Date 8 April 2024
Our Ref 24/00318/CLP

Town and Country Planning Act 1990 (As Amended)
11A Christ Church Mount, Epsom, Surrey
Lawful Development Certificate - Proposed Use: Additional vehicle crossover to access existing hardstanding driveway

11a Site Plan - Proposed Area for additional Vehicle Crossover

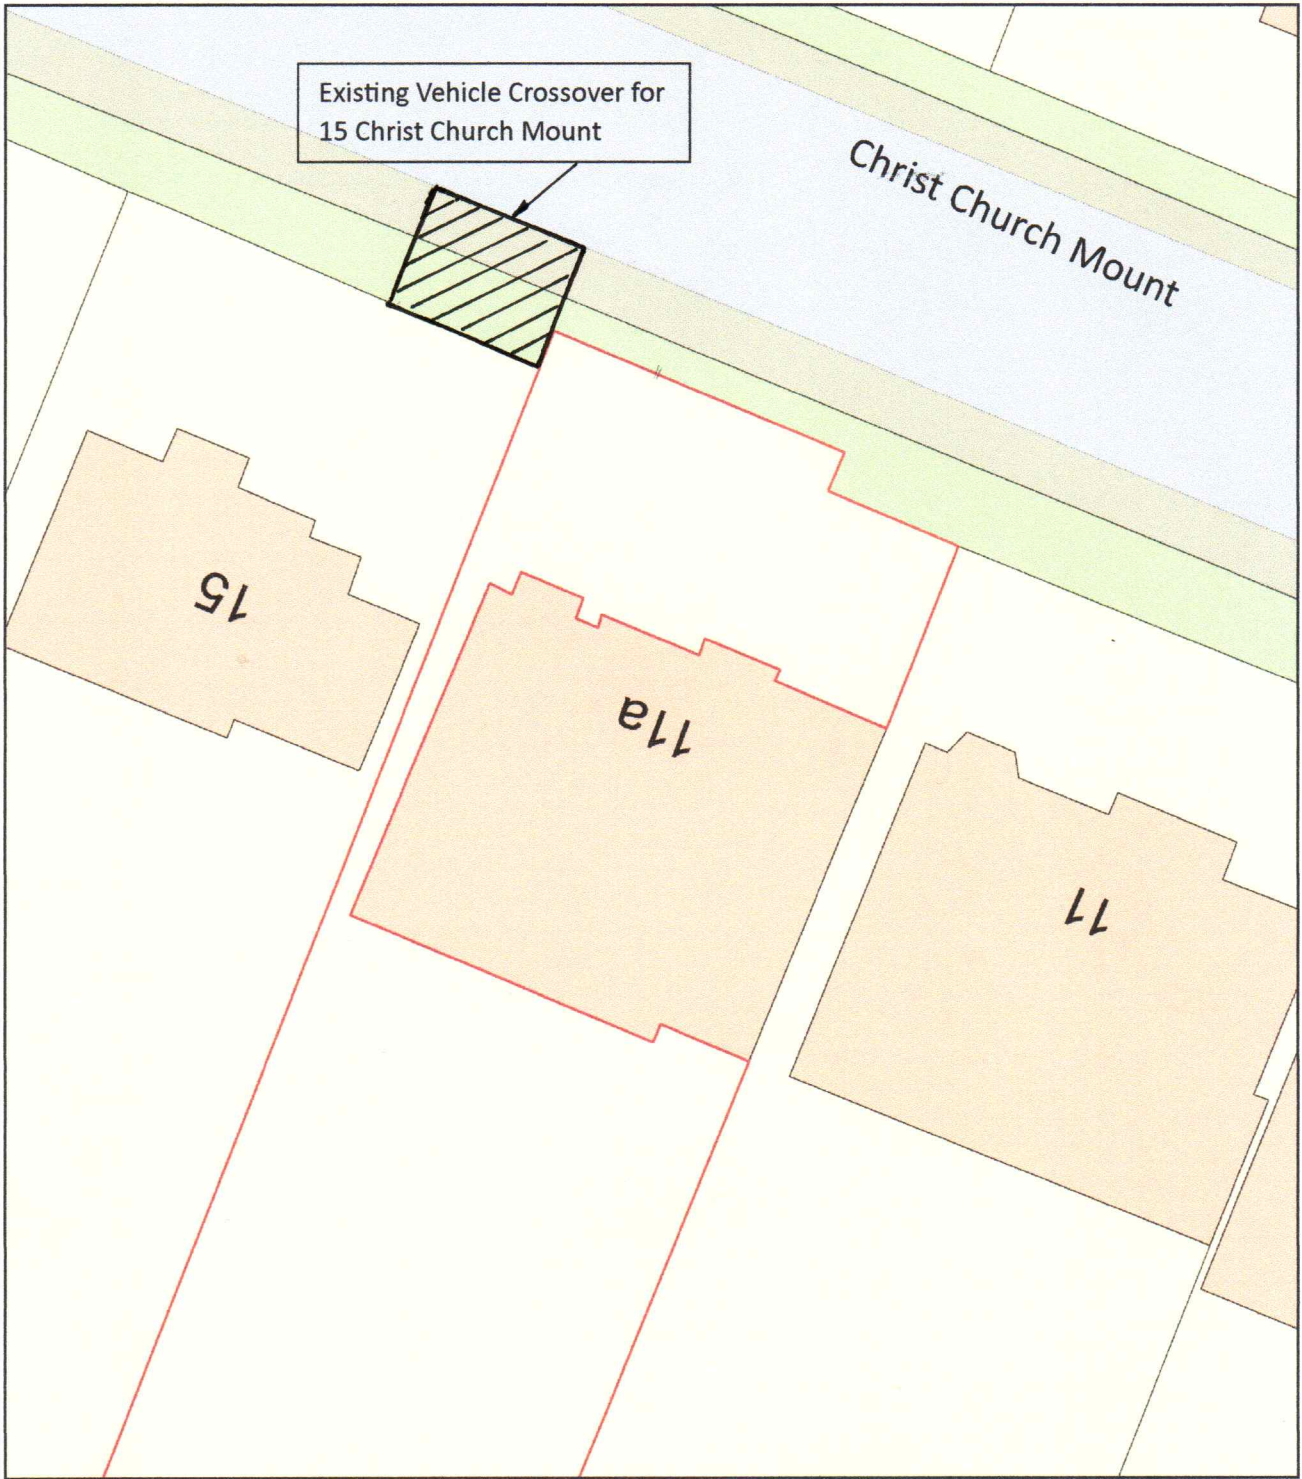
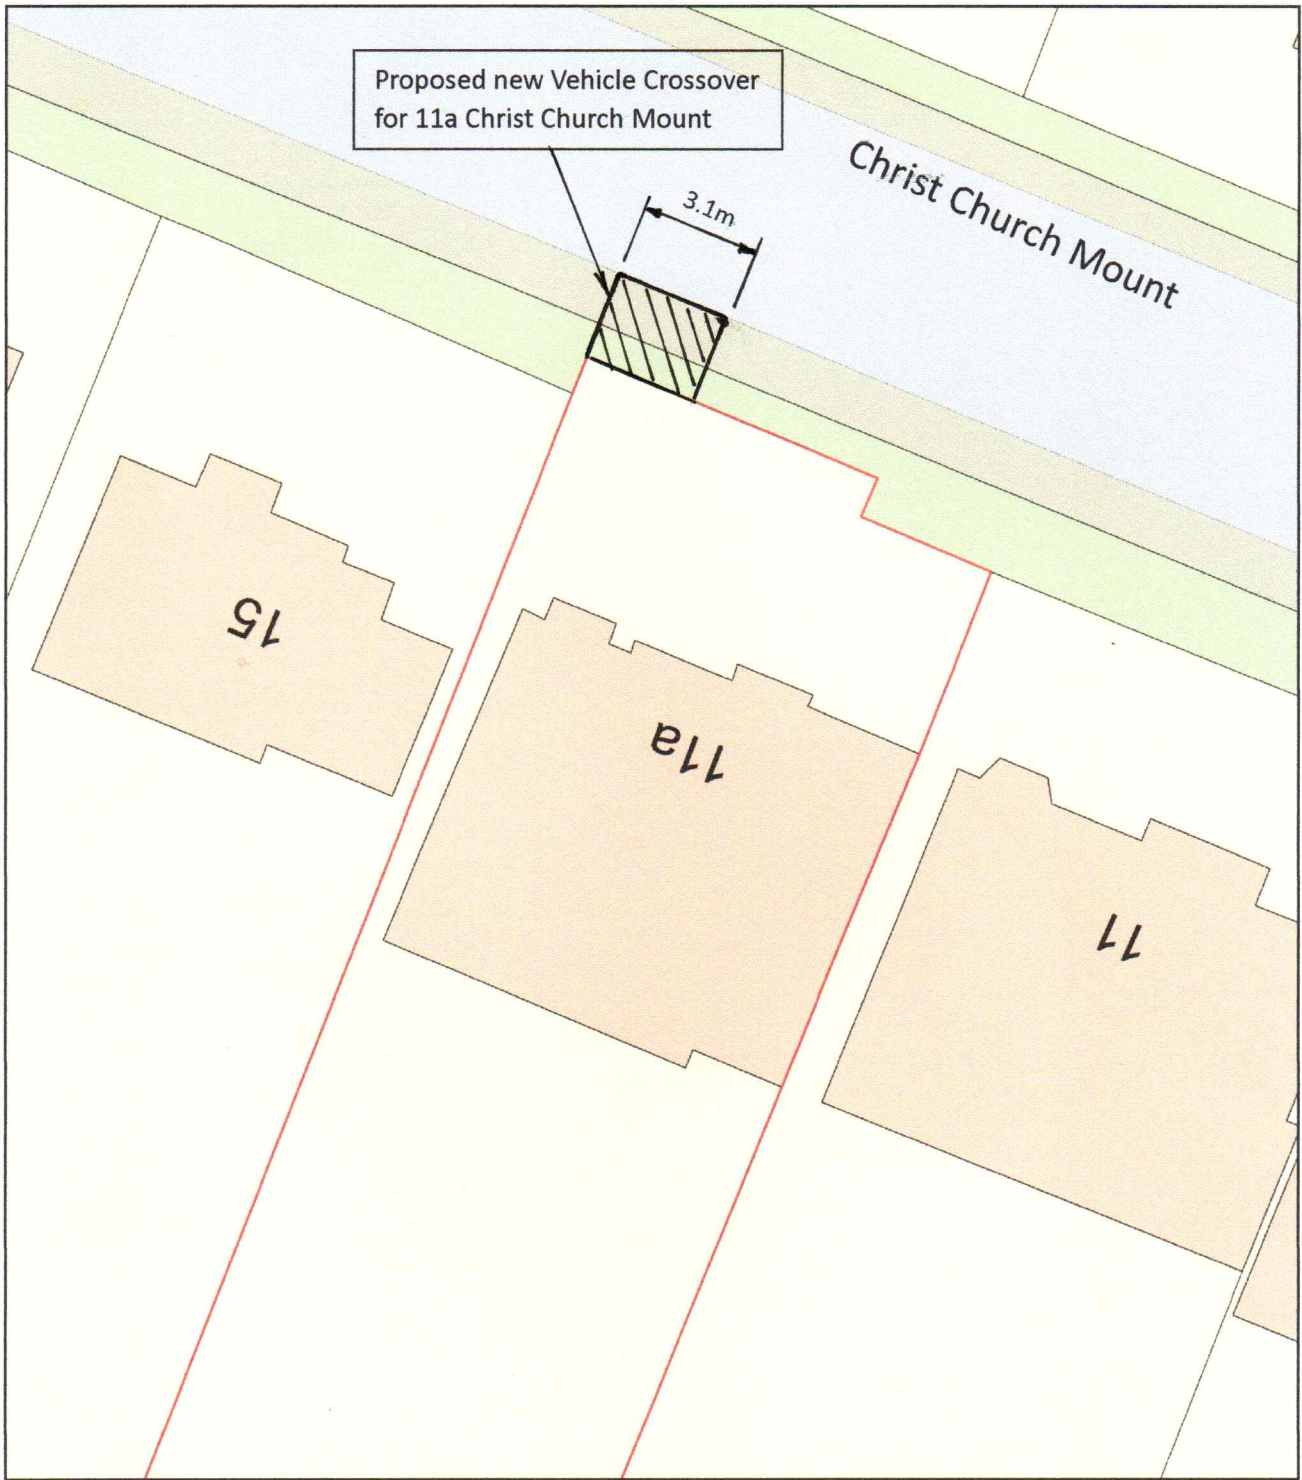
1 EXISTING AND PROPOSED SITE PLAN - Please submit an existing and a proposed Site Plan at a scale of 1:200 or 1:500 showing the proposal clearly differentiating from the existing (e.g. hatched) and its relation to the site boundaries, any other existing buildings on site and the neighbouring properties. The existing site plan is to show the current situation and the proposed plan is to show the proposed situation. As the proposal is for an additional dropped kerb, please ensure the plans incorporate the pavement up to but not including the highway.
